Project Number : 25014
Project Phase: SDP
Drawn by : RSH
Drawing Date : 31 July 2026
SP 1
Preliminary
Site Plan

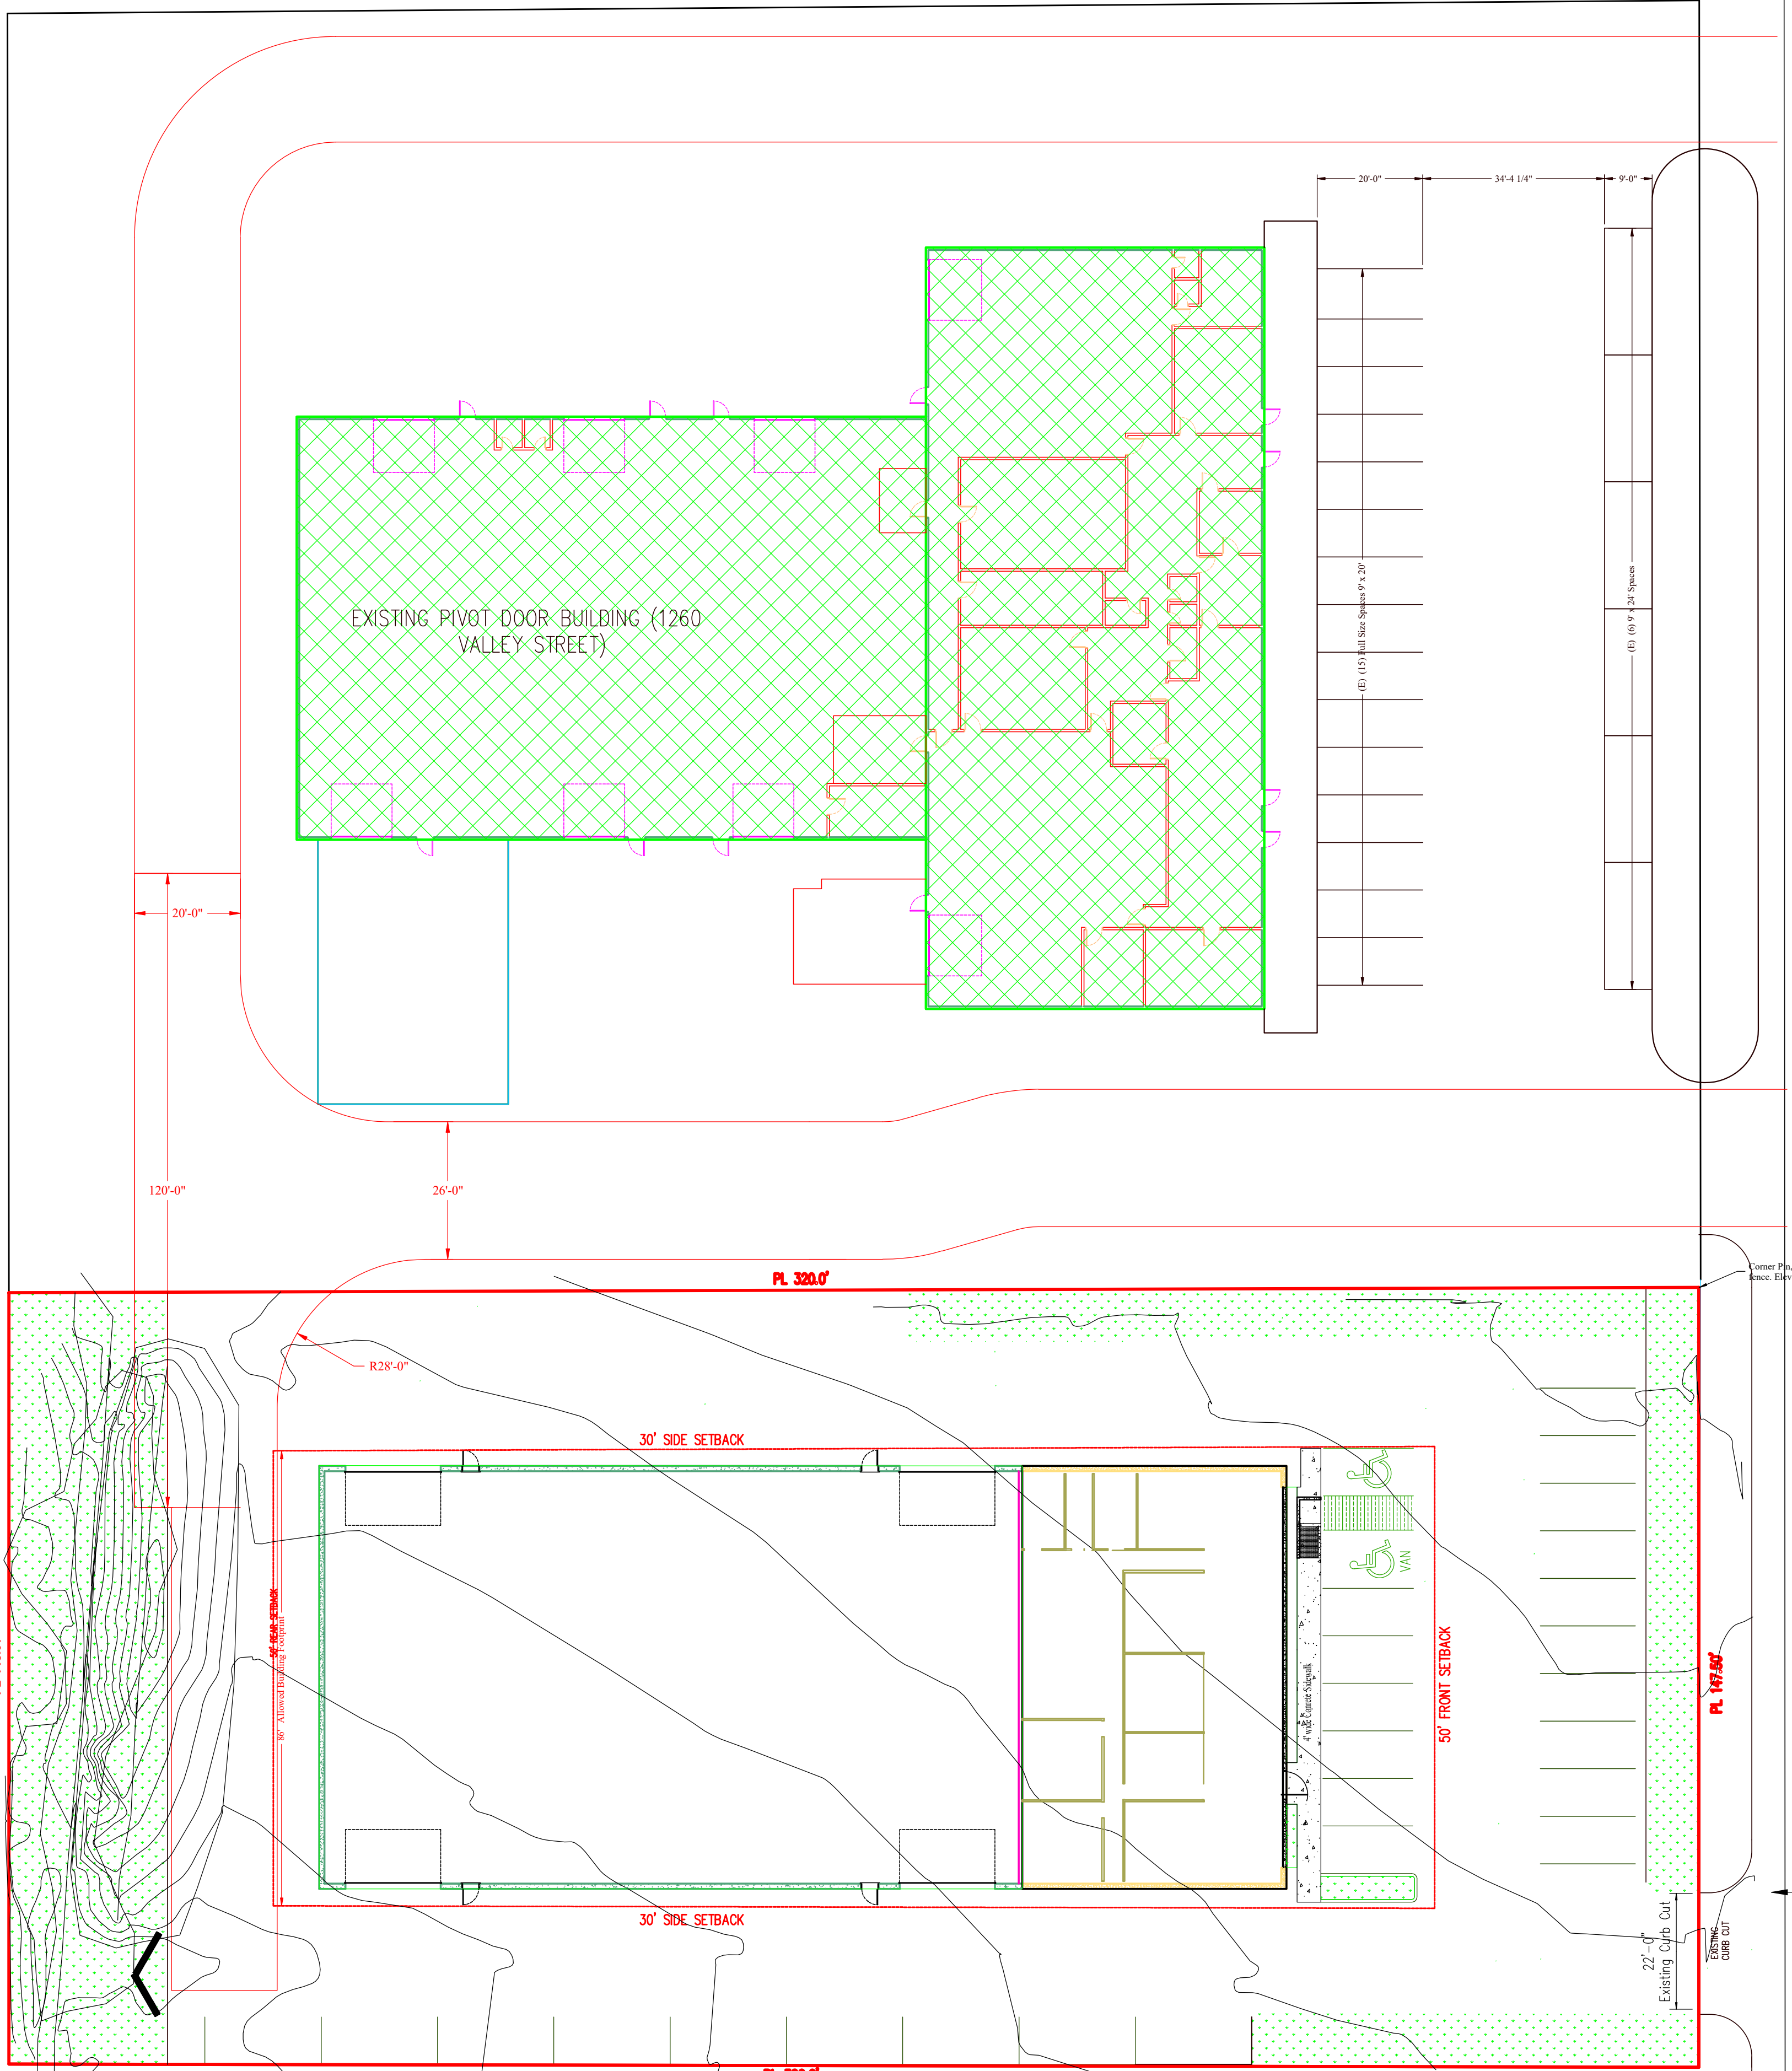
Action Item: Gas and electric meter locations on plan view and building elevations must be shown and labeled.

Action Item: Add note " Gas meters must be a minimum of 3-feet from doors, operable windows, or any vents or openings in walls."

Action Item: Add note "CSU Field Engineer to determine final gas/electric meter, transformer, and service line locations. Contact Field Engineering at 719-668-4985 (Gas) or 719-668-5564 (Electric) with any questions."
